Whalley Parish Council

PLANNING APPLICATIONS 3/2016/0064 & 3/20160066

The plans concern alterations to the surface water drainage arrangements for the Lawsonsteads development.

TITLE: **POND 'A' SECTIONS**

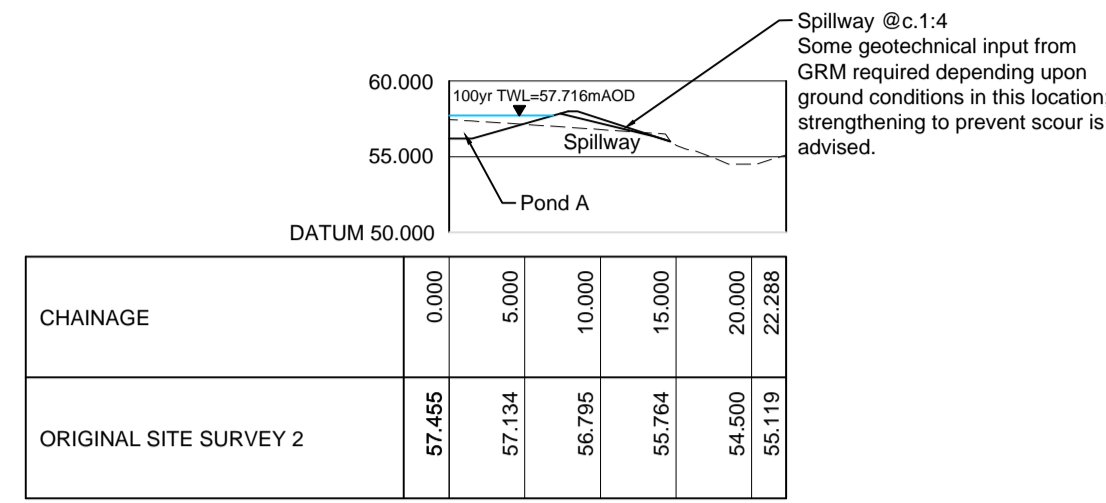
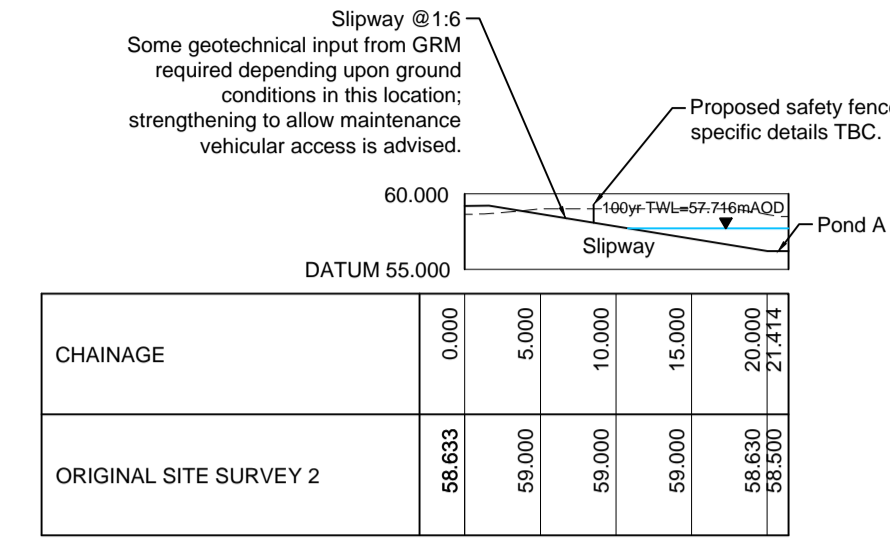
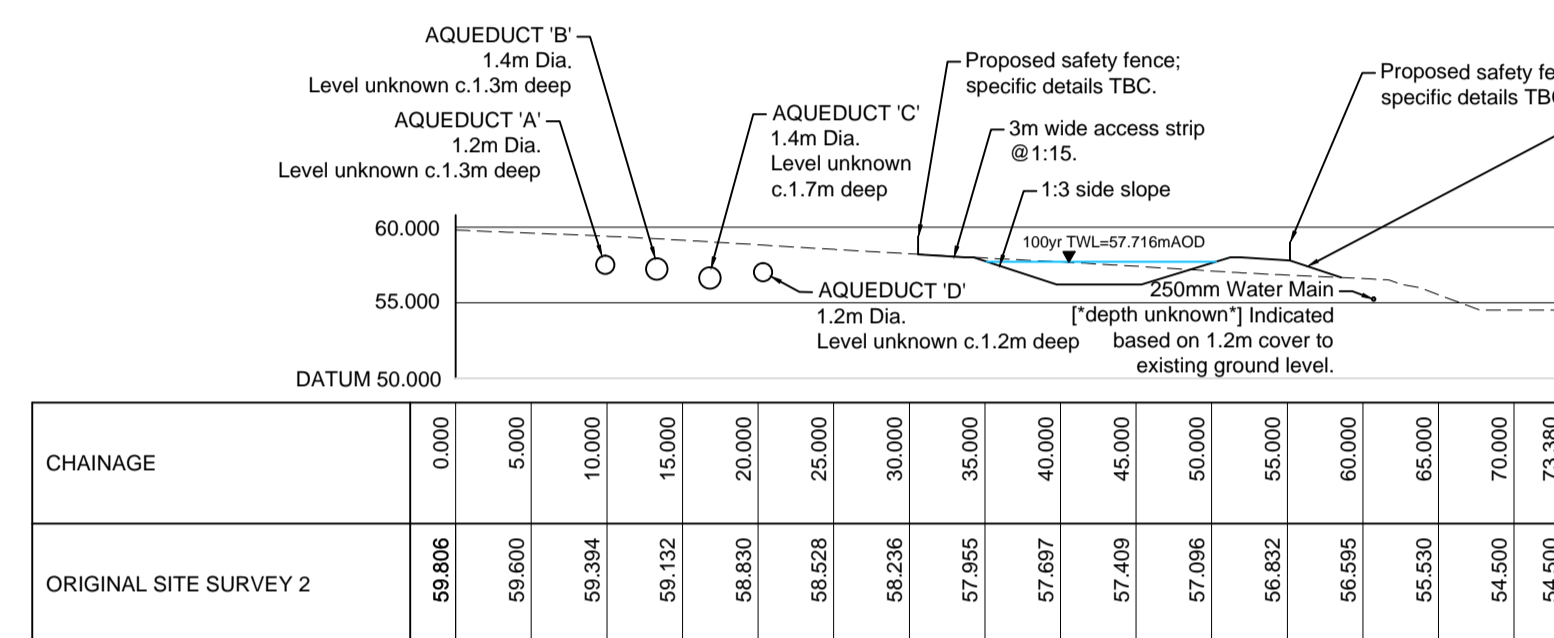
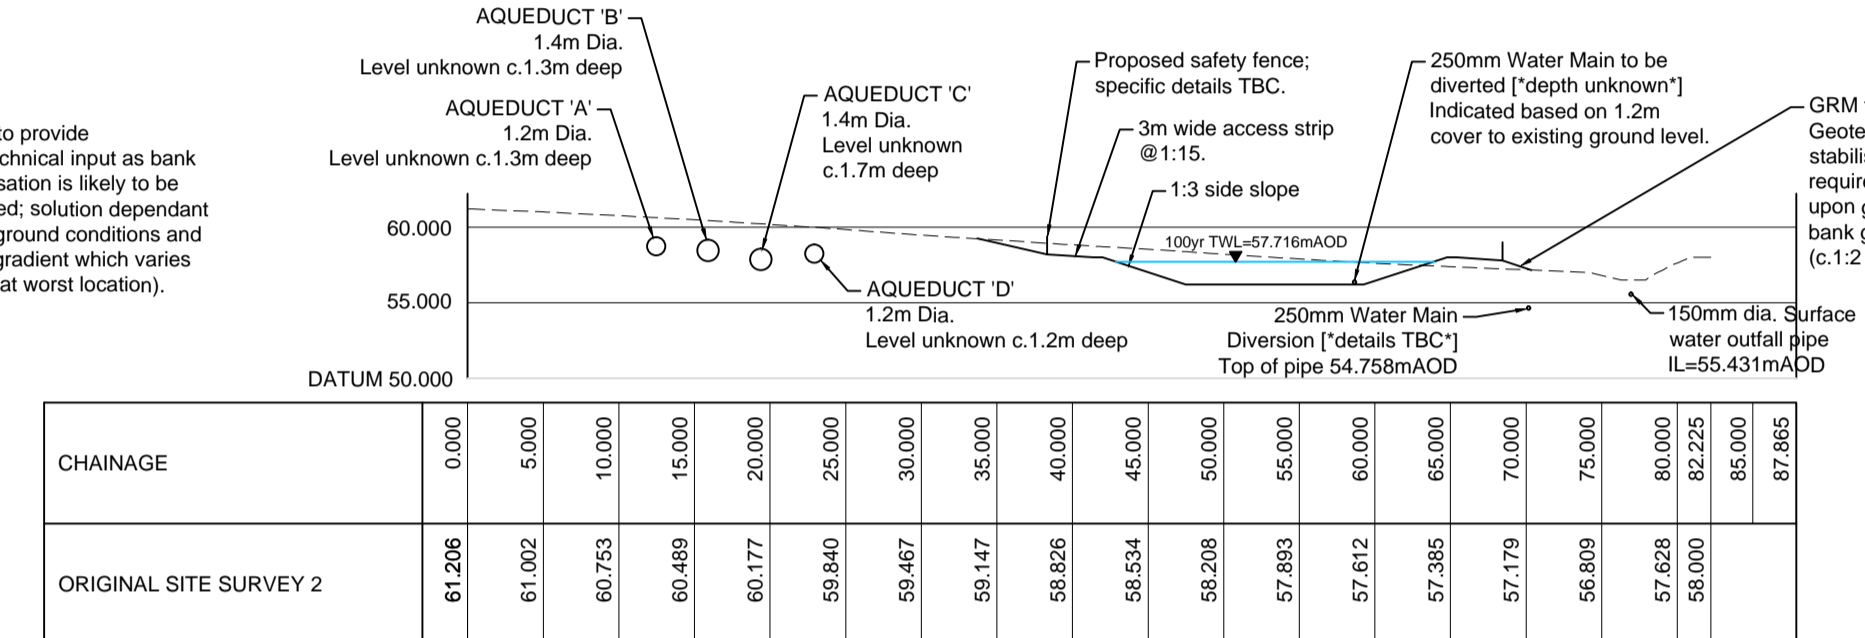
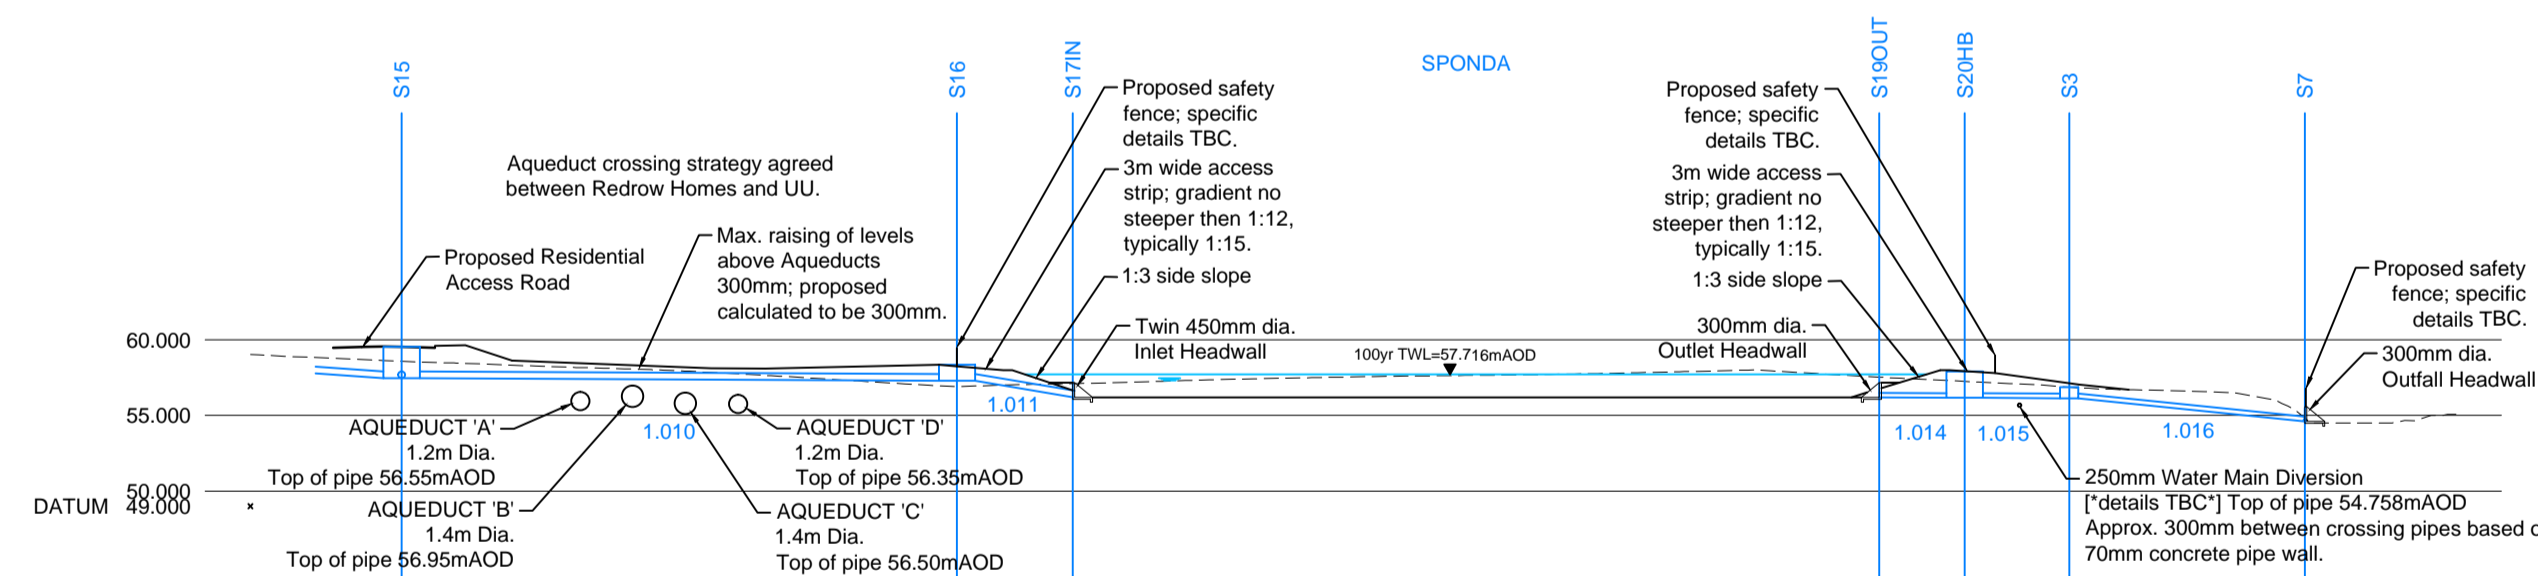
However, councillors have registered dismay in relation to the management of the outflow. The balancing ponds are intended to intercept and store surface run-off up to the level of "100year event +30%". Frankly Whalley residents and businesses have little regard for politicians and so called experts who pontificate whilst their homes and business are awash with water.

The proposals are only to intercept and store water. Logically they are a delay mechanism. Consequently the run off must discharge into local watercourses and public sewers. The public sewer in question is under Clitheroe Road which in turn is channelled to the King St culvert. The local watercourse is the brook that is culverted at the end of Brookside Close. This joins the public sewer water(as above) and continues under King St Whalley.

In light of the incontrovertible historical and recent evidence the King St culvert lacks the capacity to deal effectively with excess storm water. Parish Councillors question whether consideration has been considered regarding the consequences to the inhabitants of Whalley by adding yet more storm water to an already overburdened system.
